Landscape Response to EIA Scoping Request

**Ribble Valley Borough Council Planning
Application No. 3/2021/0174
Application No. 3/2021/0119**

**Addendum to EIA Scoping request for the installation of tunnelled pipework at
the Bowland and Marl Hill Sections of the Haweswater Aqueduct and
associated works**

25th February 2021

Drawing Title: **PROPOSED MARL HILL SECTION RIBBLE VALLEY BOROUGH COUNCIL SHEET 1 OF 1**

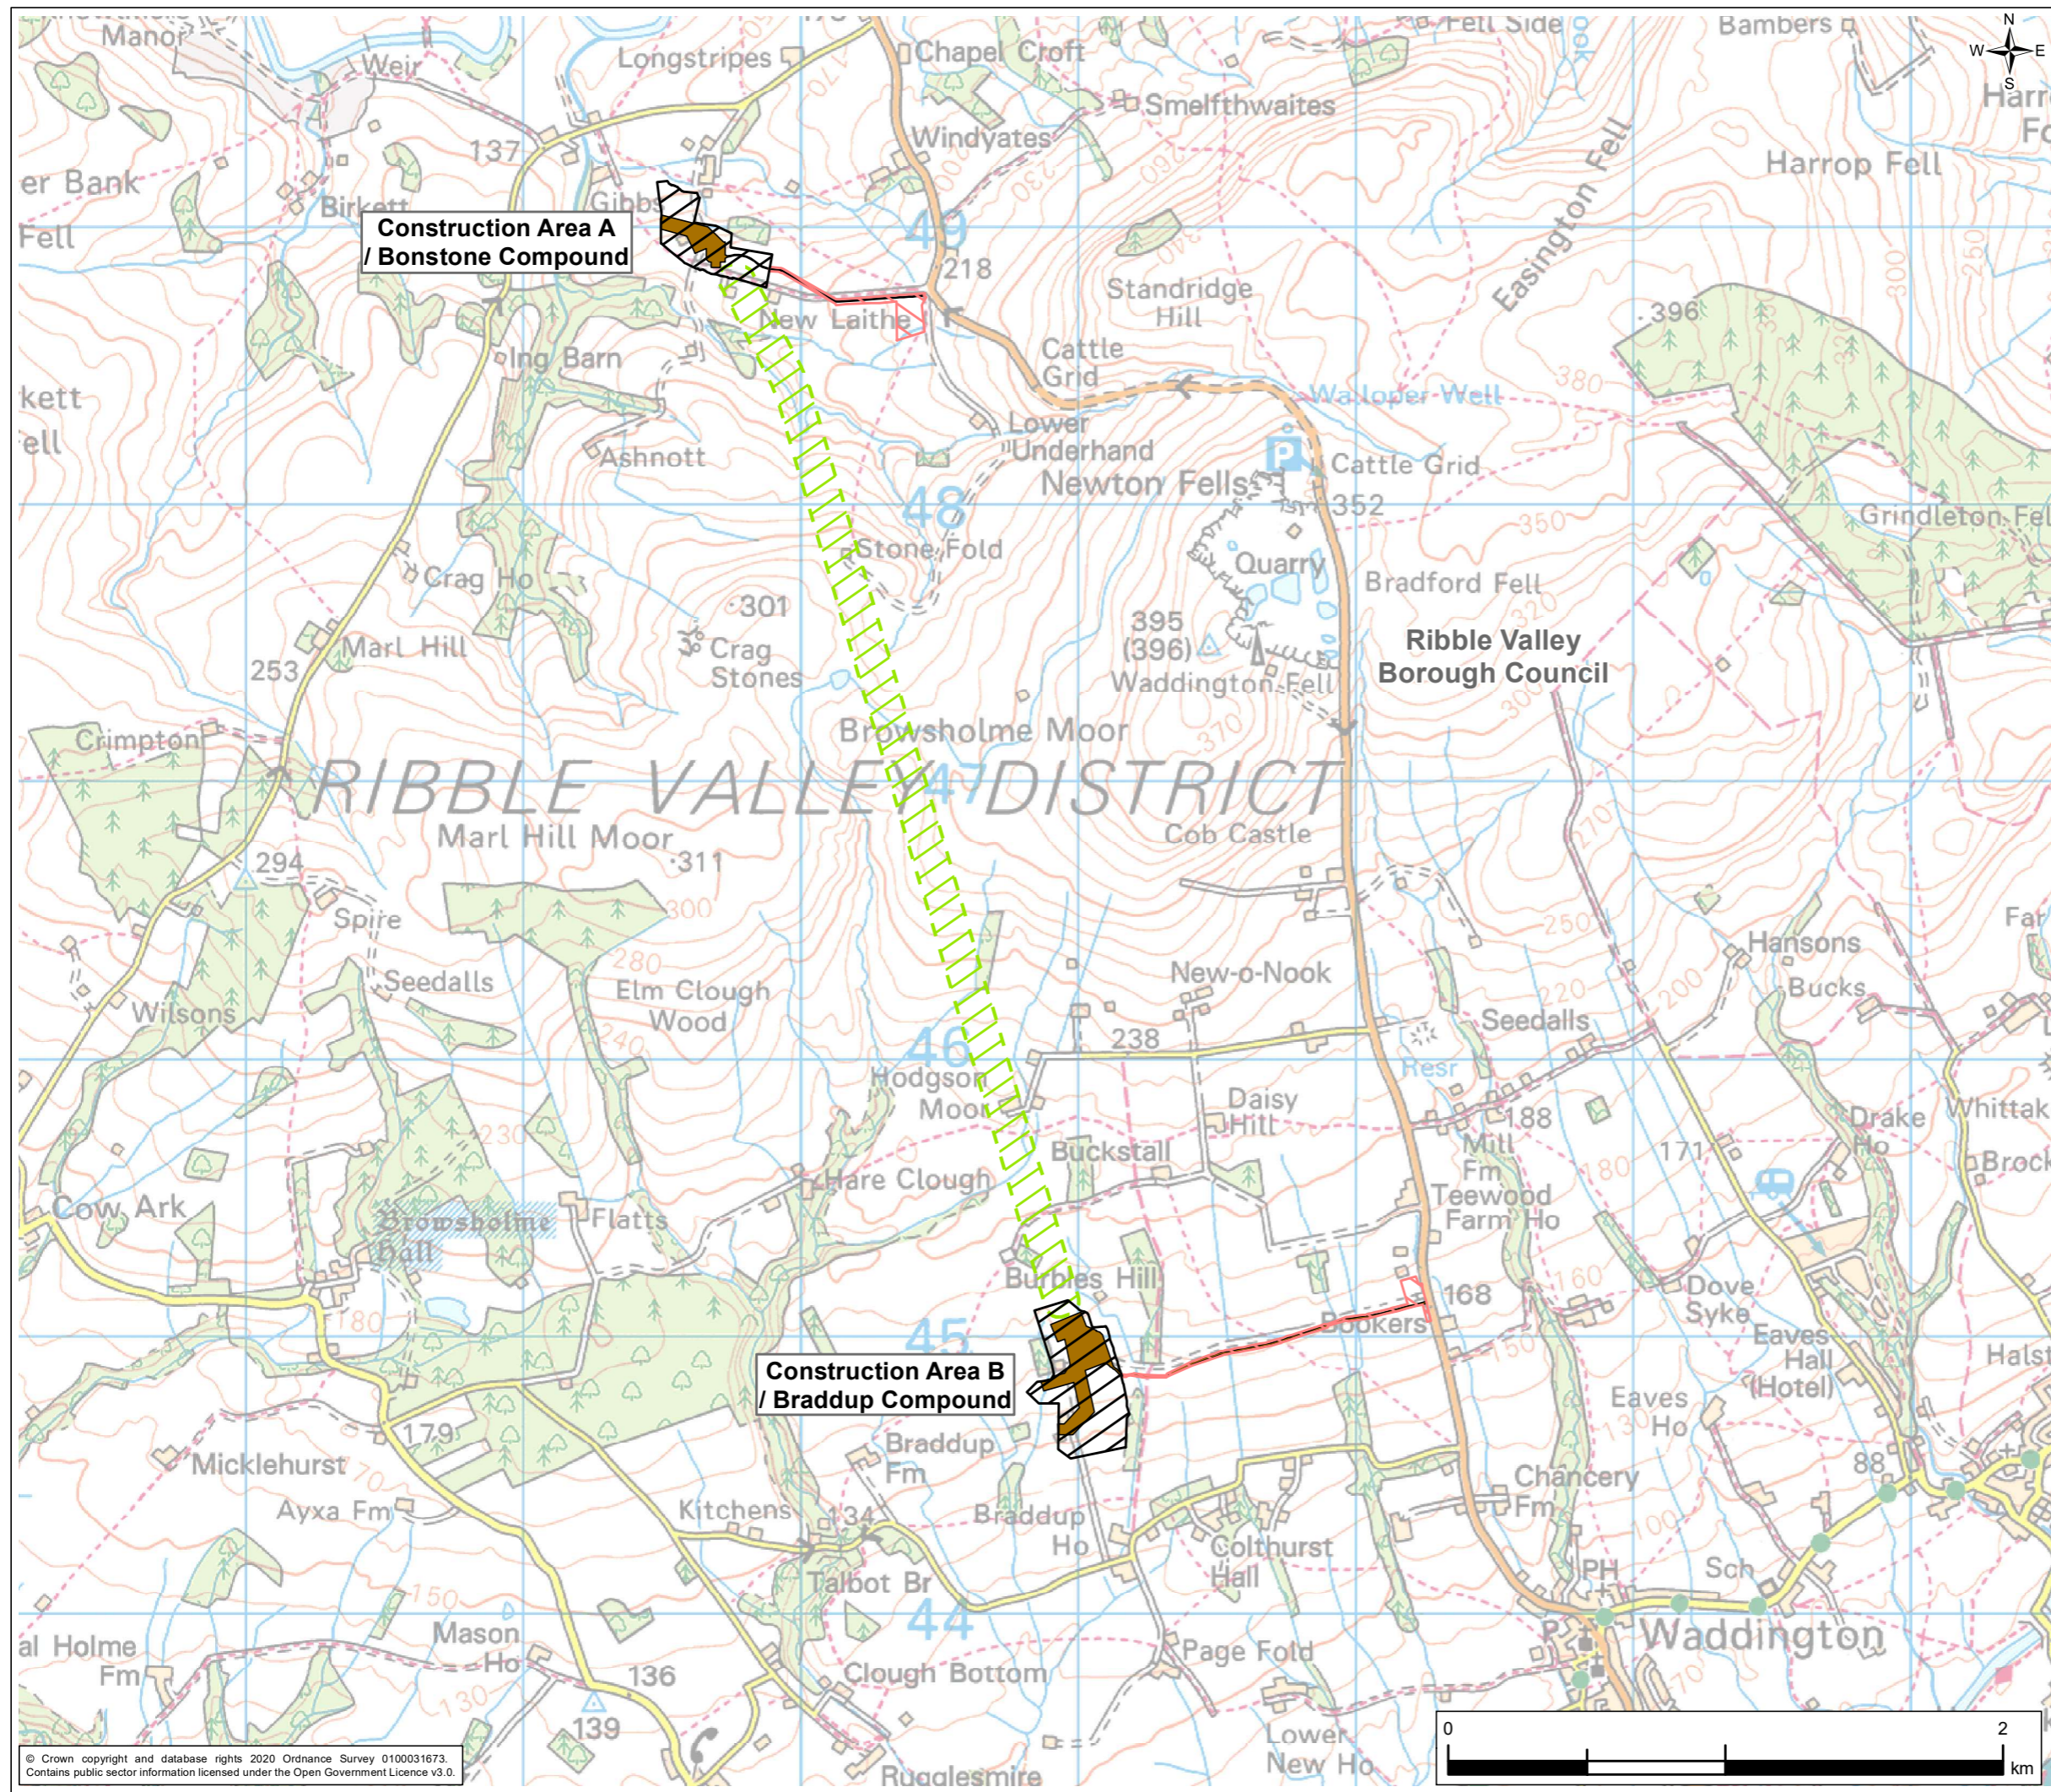
This would be a major new temporary built feature in an area of land which forms part of the setting to the Forest of Bowland AONB. The proposed Ribble crossing would be comprised of substantial civil engineering structures including an approximately 1,300 m long haul road and a 42 m (approximate) clear span bridge over the River Ribble. The report's description of the proposals differs to that provided for the Hodder Crossing in that there is a much stronger emphasis on the temporary nature of the work, e.g. "*The route would be a temporary feature that would be removed entirely following completion of the HARP construction programme in the Ribble Valley area; land would be reinstated back to its current use and setting.*" By comparison,

the description of the Hodder Crossing proposals makes no reference to removal of the features or reinstatement.

As with the Hodder crossing there is also the issue of whether the Ribble Crossing would be retained as a permanent feature, effectively creating a 'bypass' for Waddington - something which has no policy basis or justification as it is not in Ribble Valley's ***Districtwide Local Plan*** or ***Adopted Core Strategy***. The scale of the Ribble crossing engineering works would like the Hodder crossing be considerable and expensive. However, unlike the Hodder crossing, it seems that the proposed haul track would not be made to the same adoptable highway standards as the report text states that it would be a *"dedicated sealed road across open farmland."* It is not clear what this surfacing would be although some form of granular aggregate seems likely but it should be borne in mind that this could be easily upgraded to a highway standard if required and, with much of the construction work already undertaken as part of the HARP project, the cost of doing this would be substantially lower than it otherwise would have been.

To achieve certainty regarding removal of the temporary Ribble crossing, if the determining authority is minded to approve the application, it is once again recommended that consideration be given to ensuring that approval be subject to agreement made between United Utilities and Ribble Valley Borough Council over removal details, timescales, remediation works, completion date, etc.

In many ways, the landscape of the area the Ribble Crossing shares similar characteristics to the area the Hodder crossing would be within. Situated within a valley - albeit a much broader one than that of the River Hodder - the Ribble crossing site is also mostly comprised of pasture with field boundaries often lined with trees and hedgerows some of which would likely have to be removed to make way for the proposed structures. This limited vegetation cover - there are no copses or areas of woodland within the site - and the gently rising topography of the valley sides affords good intervisibility with the surroundings which includes Waddington Conservation Area. The valley is also crisscrossed by a network of public rights of way which also afford good visibility of the site. This visibility combined with the open farmland, elevated topography of the surrounding area and limited existing vegetation which could filter views all suggest that the new Ribble crossing structures would likely be prominent features in the landscape which forms part of the setting to the Forest of Bowland AONB. For all these reasons, I have reservations regarding the choice of this site for a temporary haul route and crossing over the River Ribble and am concerned that the civil engineering features would not protect, conserve or enhance the setting to the nationally important Forest of Bowland AONB.
